RE: Lot 1 Independence Place at Cheyenne Mountain Filing No. 1A – Ponds A & B

This letter is intended to provide documentation with the County inspection Staff that Ponds A and B facilities in Lot 1 Independence Place at Cheyenne Mountain Filing No. 1A have been constructed in general conformance with the approved pond designs. WestWorks Engineering has reviewed the final construction facilities and survey as-builts by others confirming the appropriate size and design. Based upon this information and information gathered during periodic site visits to the project during construction, WestWorks Engineering is of the opinion that these stormwater BMP's have been constructed in general compliance with the approved construction plans and specifications as filed with El Paso County.

FOREBAY WALL DETAILS - STM-05 DISCHARGE
SCALE: N.T.S.

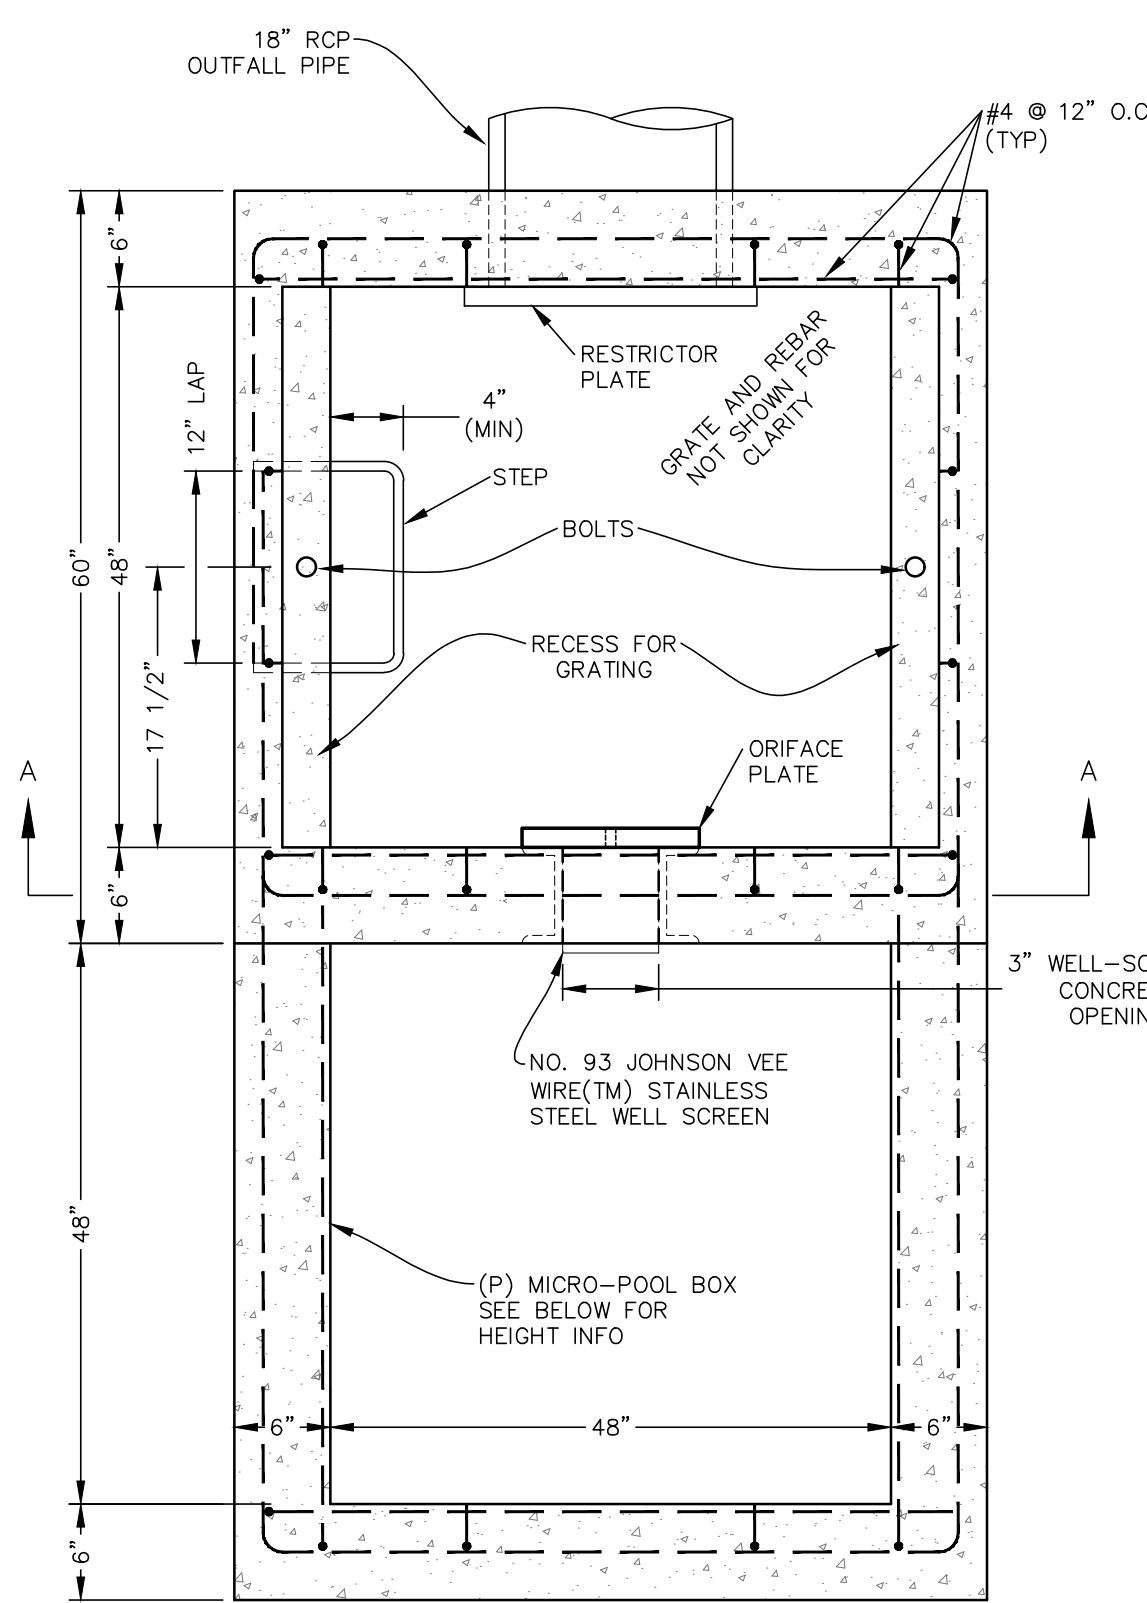
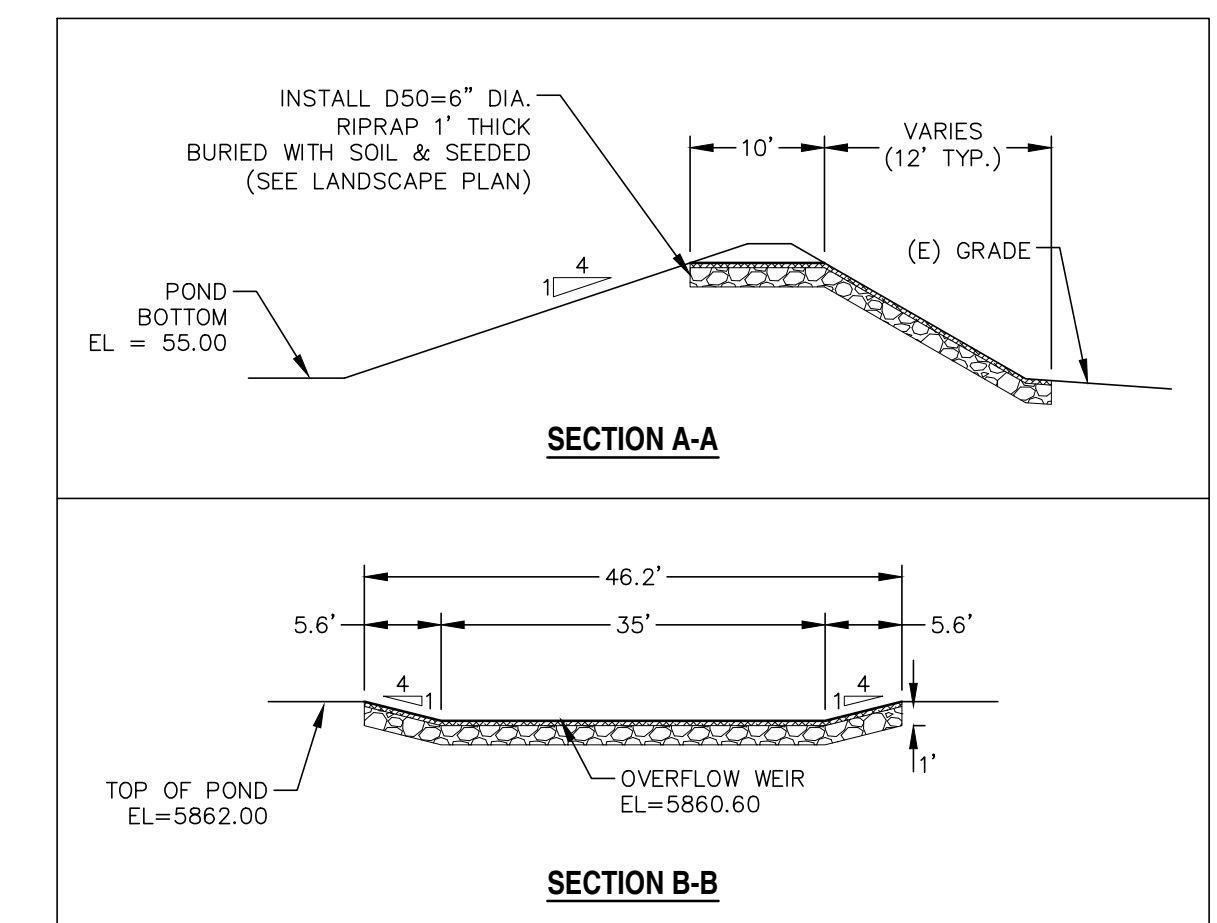
If any of the as-built changes to the pond design will effect the drain time:

Please update the MHFD-Detention Spreadsheet with the updated as-built information (pond elevations, spillway length, orifice hole elevations, etc.) to confirm that the pond is functioning as intended. The updated Spreadsheet should be attached to the Pond Certification Letter.

Include As-built condition stamp and EOR signature on each sheet. Per ECM 5.10.6 Engineering Record Drawings: Each sheet of the record drawings shall be designated as "Engineering Record Drawings" and signed and dated by the engineer of record.

Even if everything was built exactly per plan, we need an electronic PDF of the original drawings to be signed, dated, and stamped with "As-Built" on each sheet.

Differences from design to as-built conditions to be shown in red text with red clouds/bubbles.
